**Consultation Response from KC,
Lead Local Flood Authority**

2024/92806 Land at, Penistone Road, Fenay Bridge, Huddersfield, HD8 0AW

Discharge of details reserved by conditions 20 (surface water discharge), 21 (flood routeing) and 31 (grass-crete and batter maintenance) of previous permission 2022/93154 for erection of 68 dwellings with associated access, parking, open space, landscaping and infrastructure works (including installation of surface water attenuation tank)

Date Responded: 25th October 2024

Title: Exceedance Flow Routes

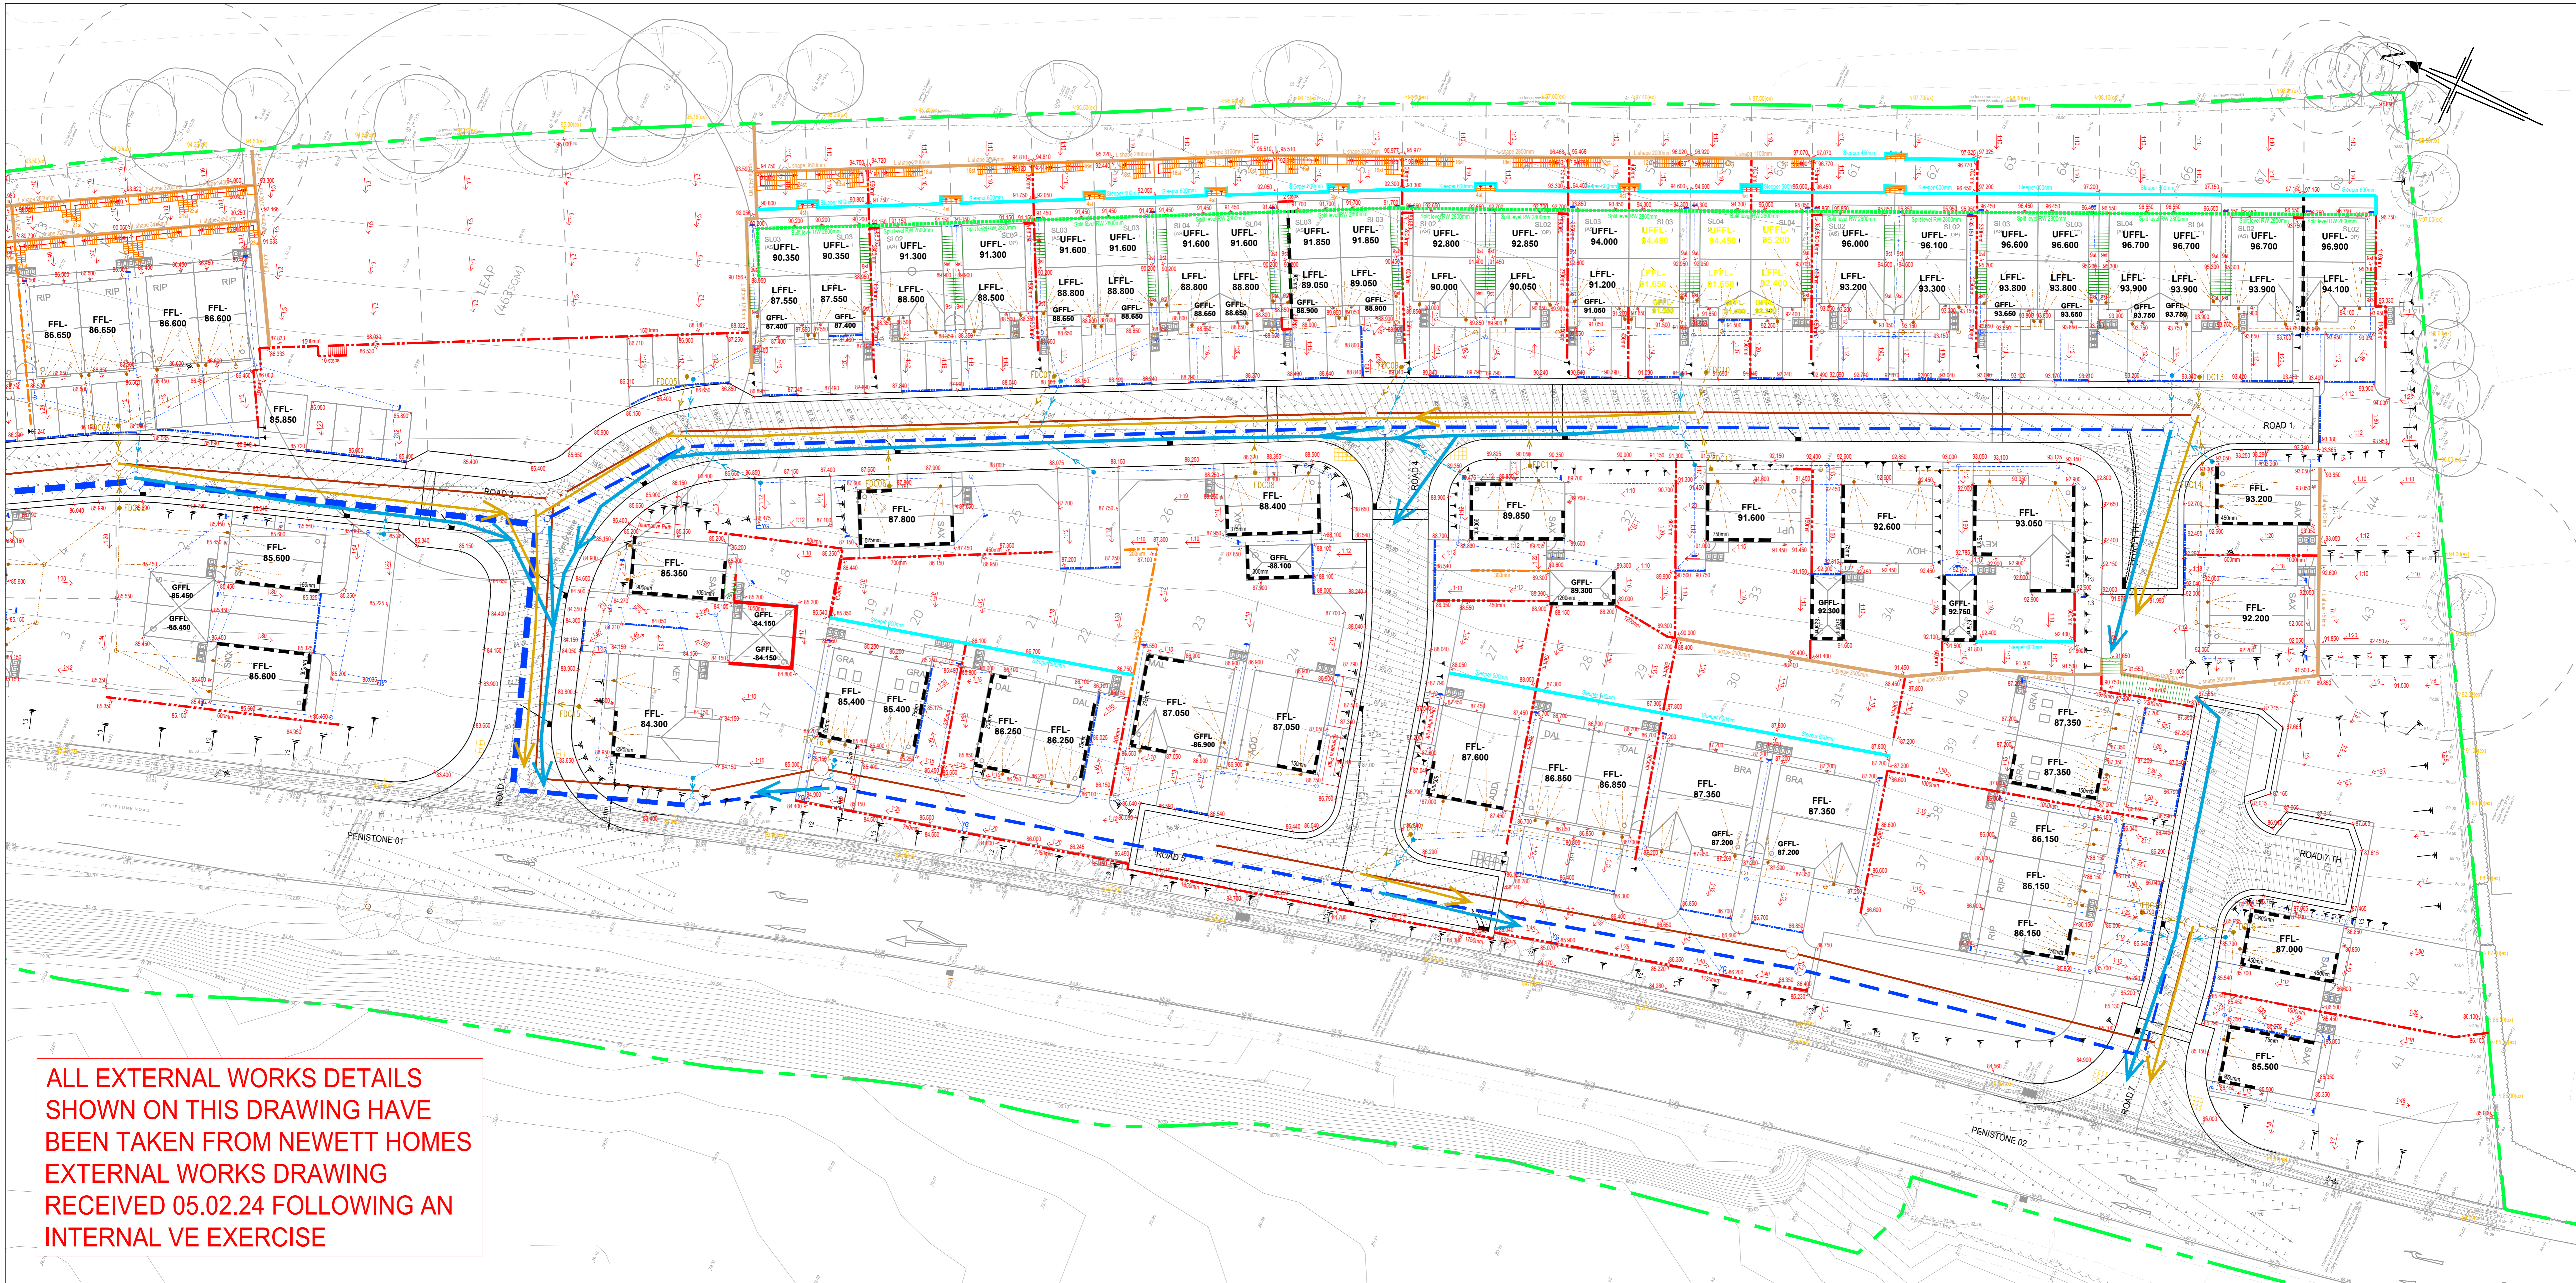
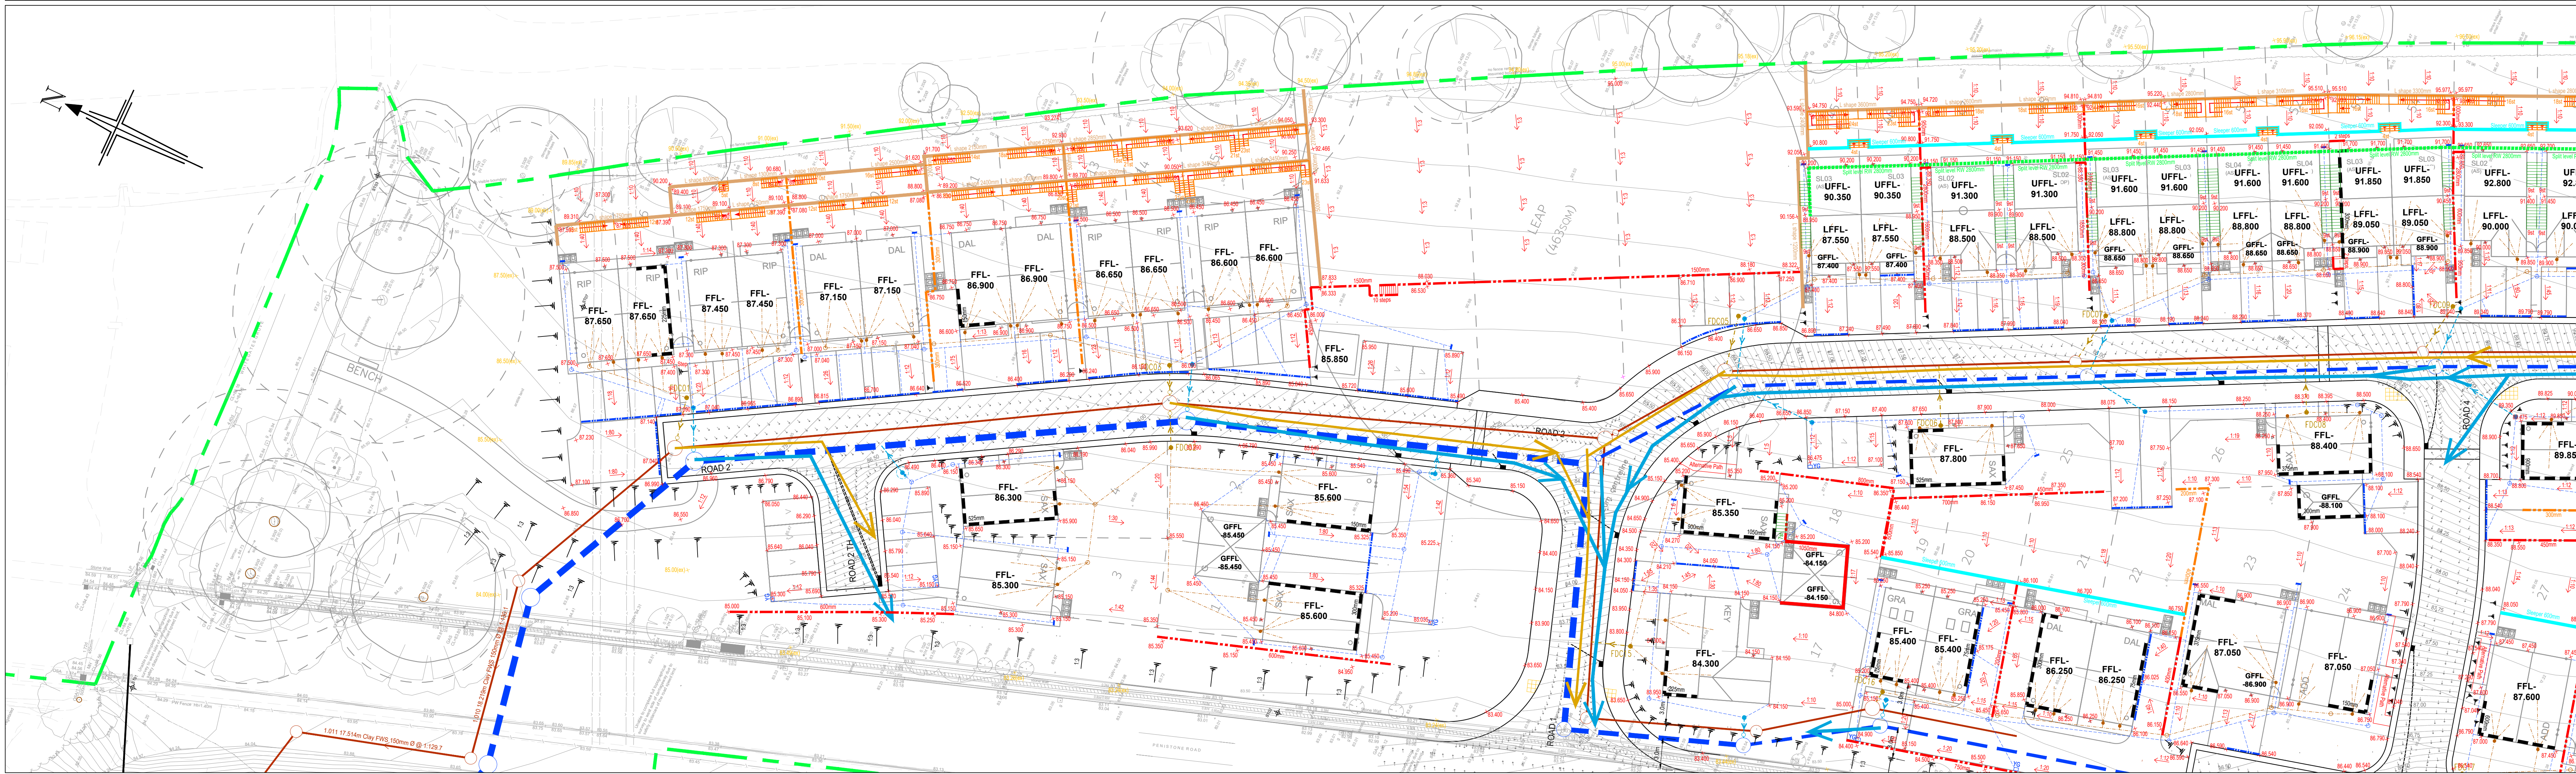
Sufficient Information has been supplied to provide an acceptable flood routing scheme.

We recommend that this condition be discharged.
